## **Development Facilitation Team (DFT) – Review Comments**

**Project No: PR-2020-004596      Date: 03/27/2024      Agenda Item: #3 Zone Atlas Page: D-10**

**Request: PRELIMINARY PLAT EXTENSION FOR 30 ACRE DEVELOPMENT TO INCLUDE 162 TOWNHOME LOTS, 1 MULTI FAMILY RESIDENTIAL LOT WITH 175 APARTMENT UNITS AND 1 COMMERCIAL LOT WITH A TOTAL OF APPROXIMATELY 21, 955 SQUARE FEET OF BUILDING SPACE. PRELIMINARY PLAT ORIGINALLY APPROVED MARCH 29, 2023 BY THE DRB.**

**Application For: SD-2024-00045-EXTENSION OF PRELIMINARY PLAT (DHO)**

PLAT OF  
UNIVERSE VIEW SUBDIVISION  
BEING A REPLAT OF LOT 1, BLOCK 8  
UNIT 17, VOLCANO CLIFFS  
LOCATED WITHIN SECTION 22, TOWNSHIP 11 NORTH  
RANGE 2 EAST, N.M.P.M.  
CITY OF ALBUQUERQUE  
BERNALILLO COUNTY, NEW MEXICO  
MARCH 2023

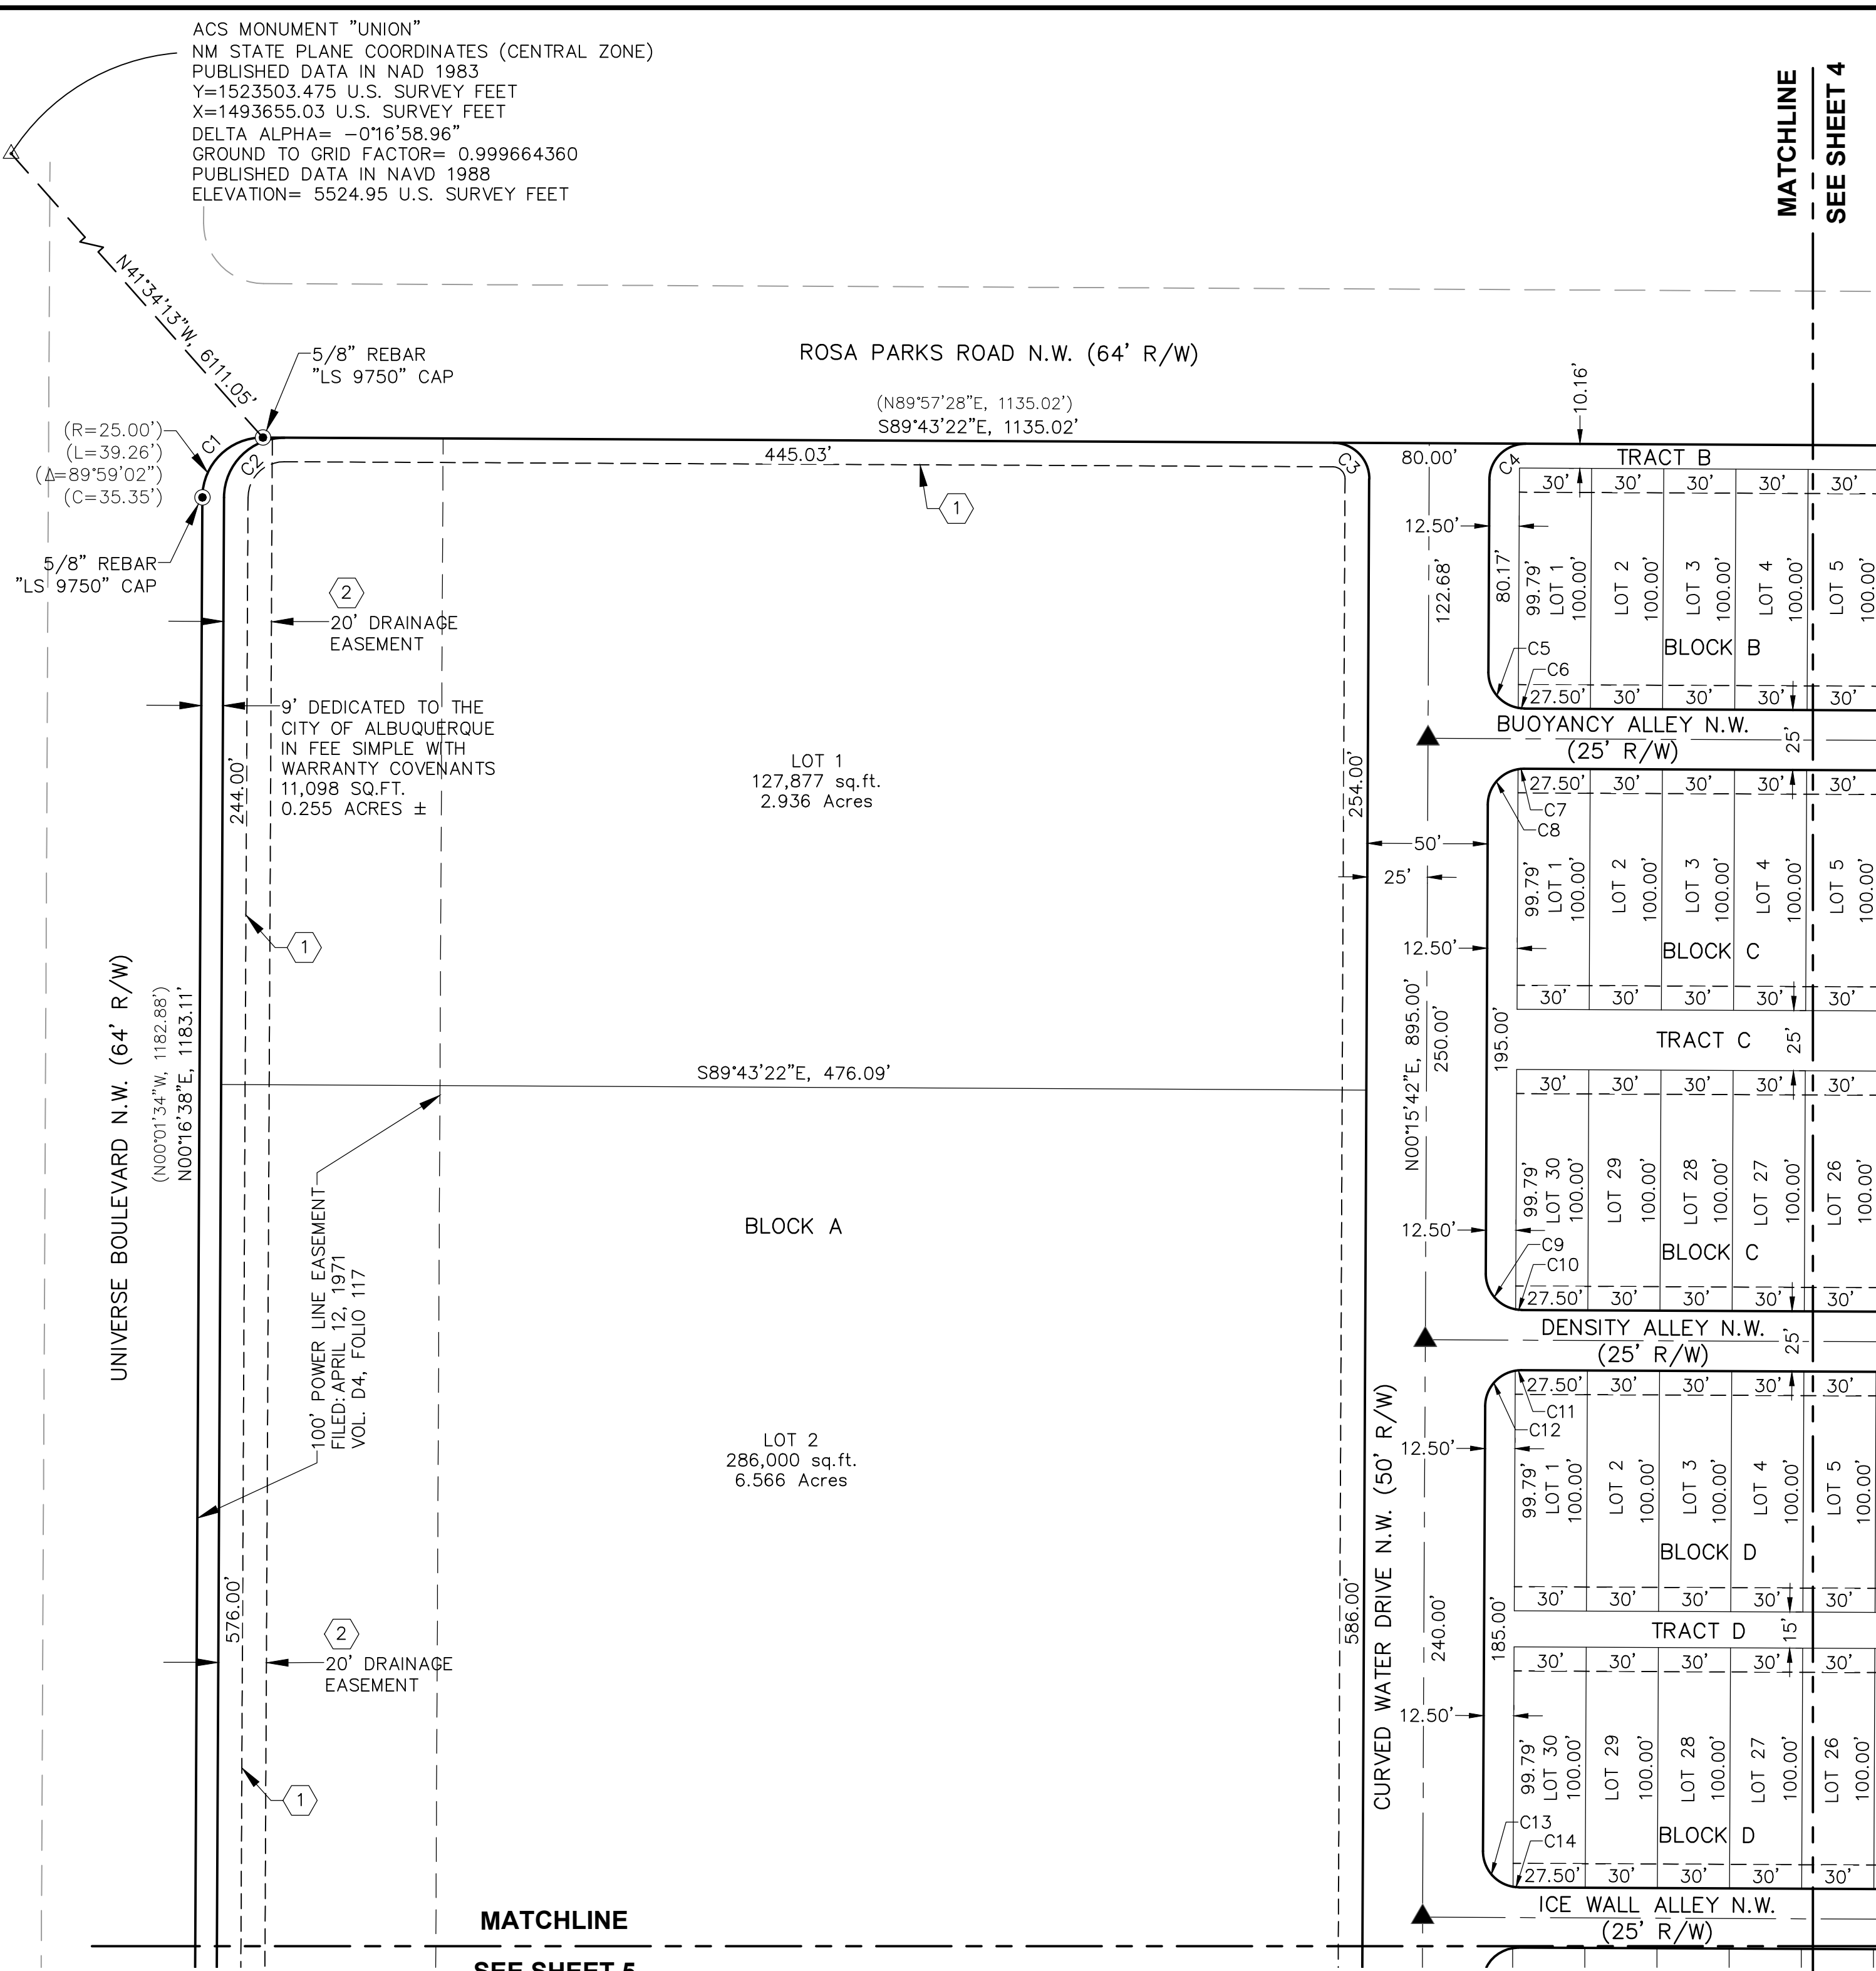
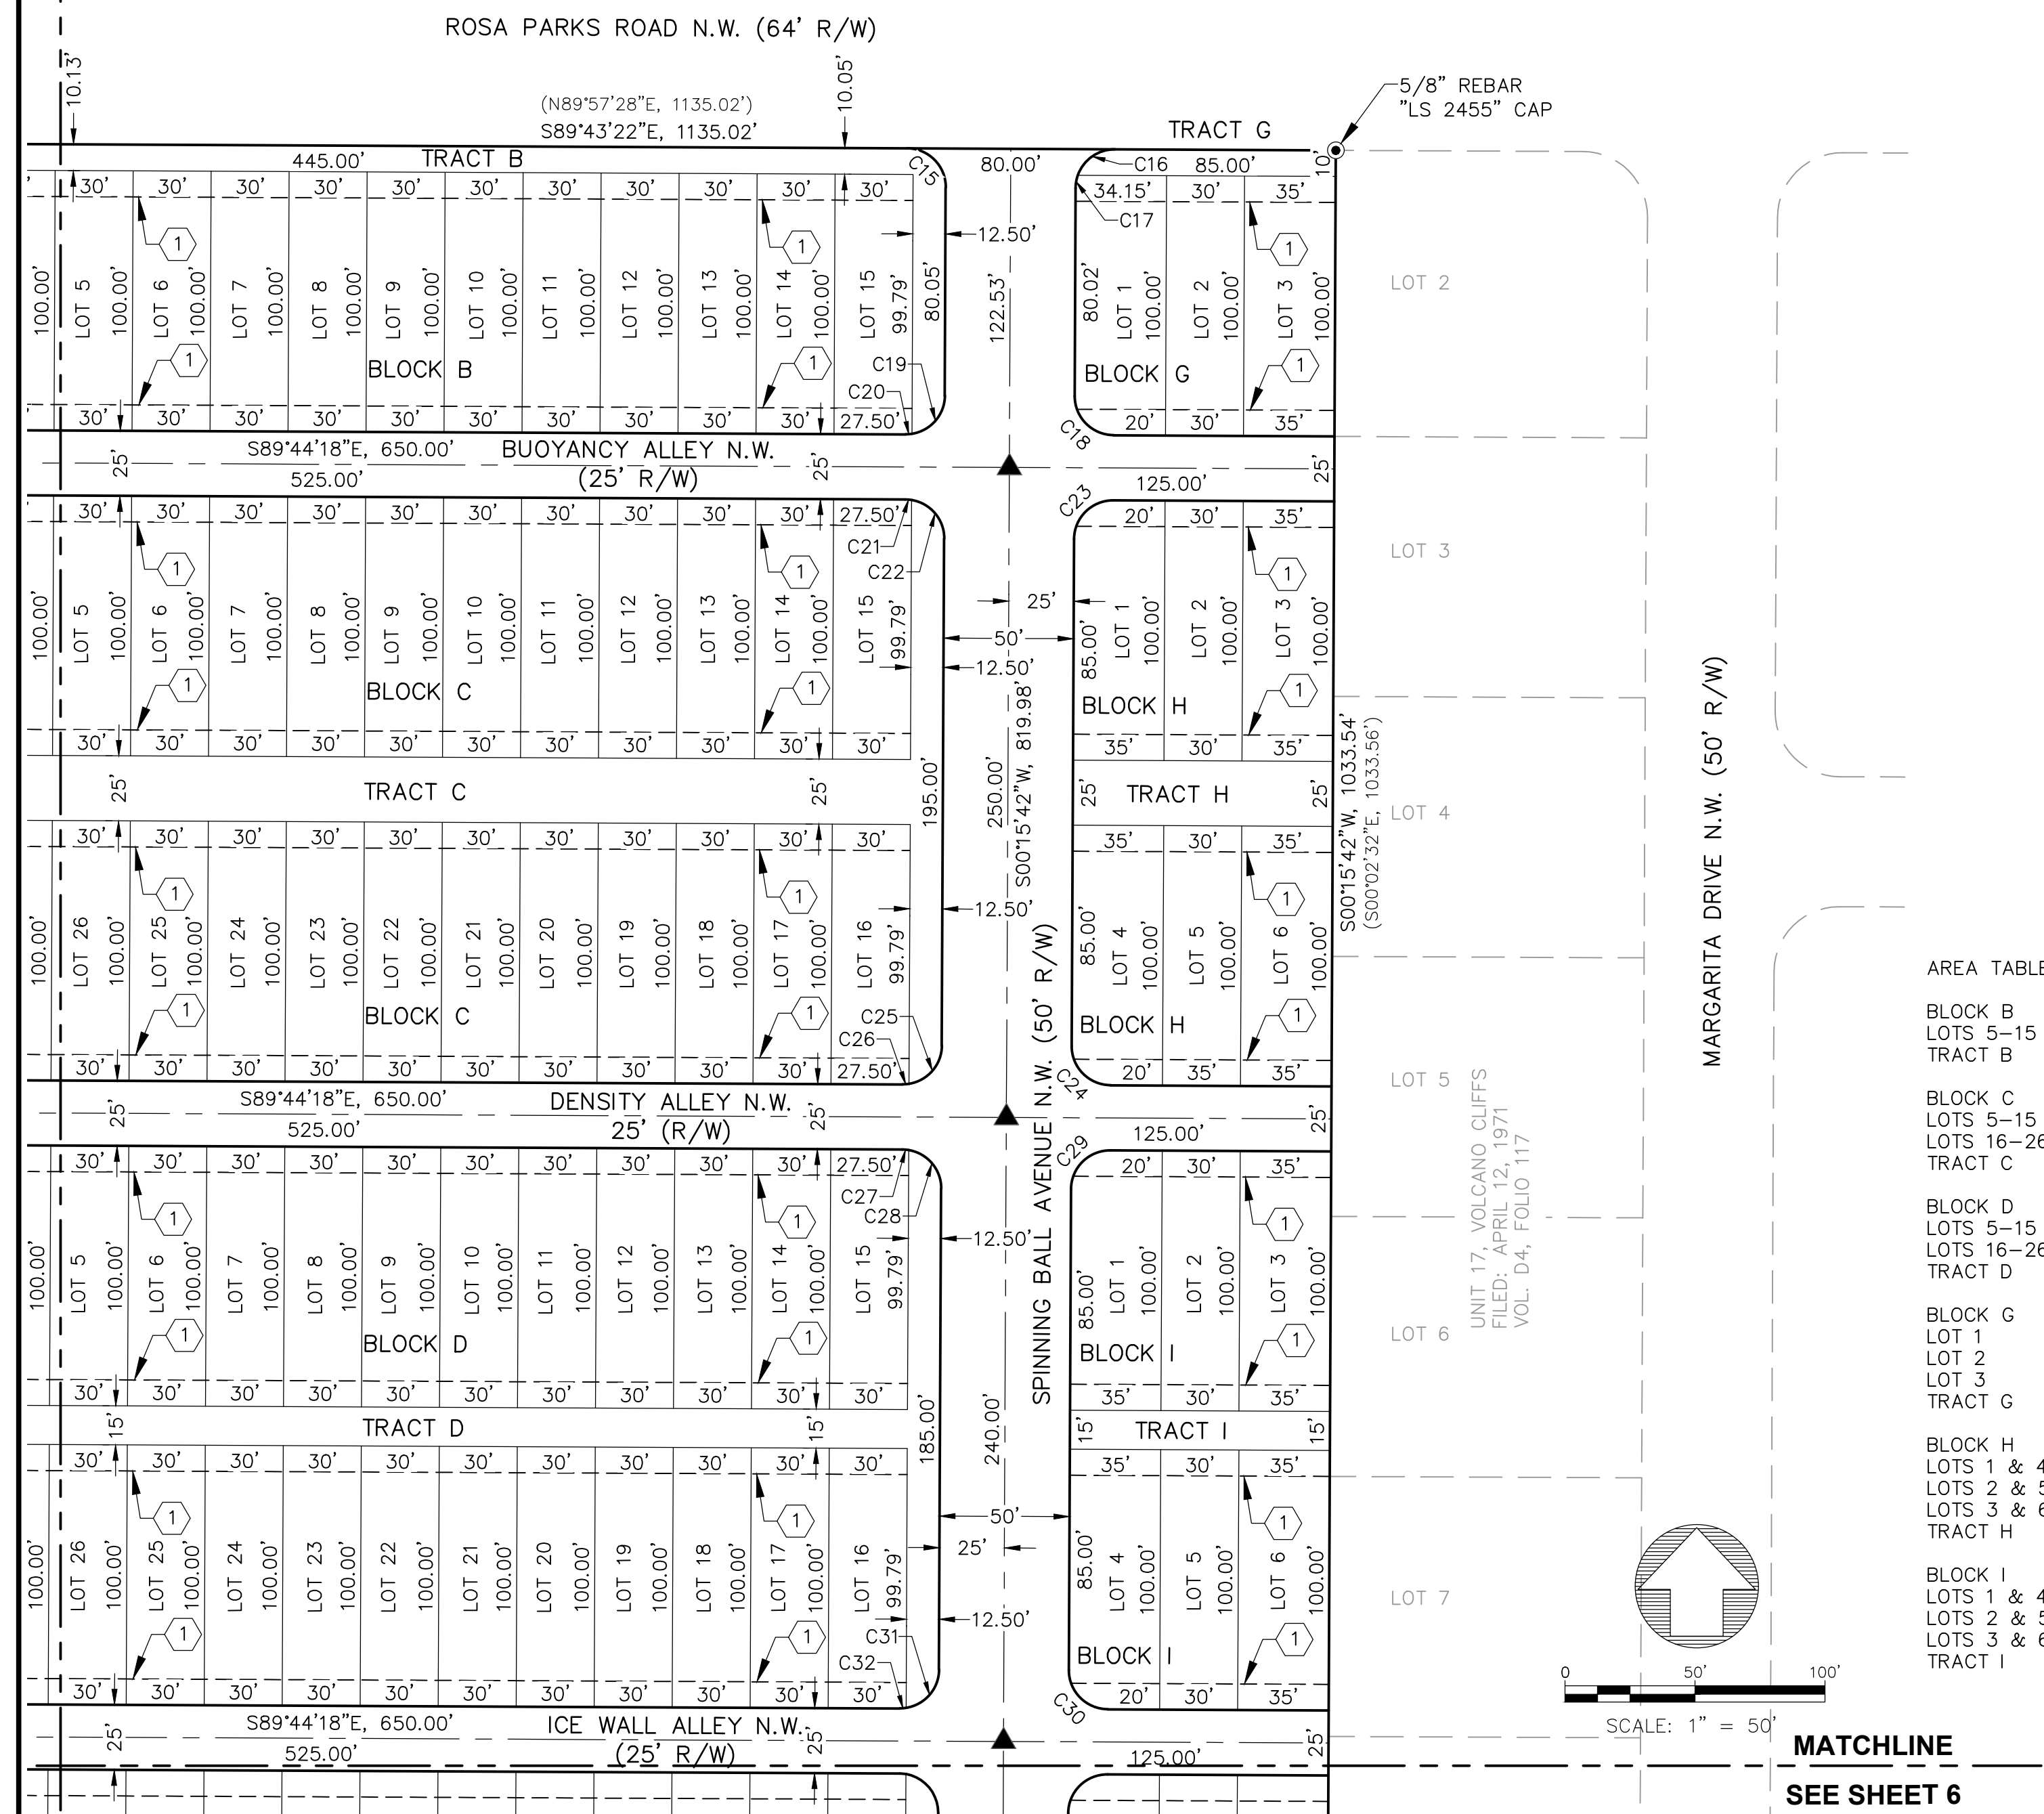
- Please confirm for the DHO that this request has no changes from the original DRB approval including any changes to lot numbers, sizes, and/or configurations, as well as any changes to easements and/or notes depicted on the original Preliminary Plat.
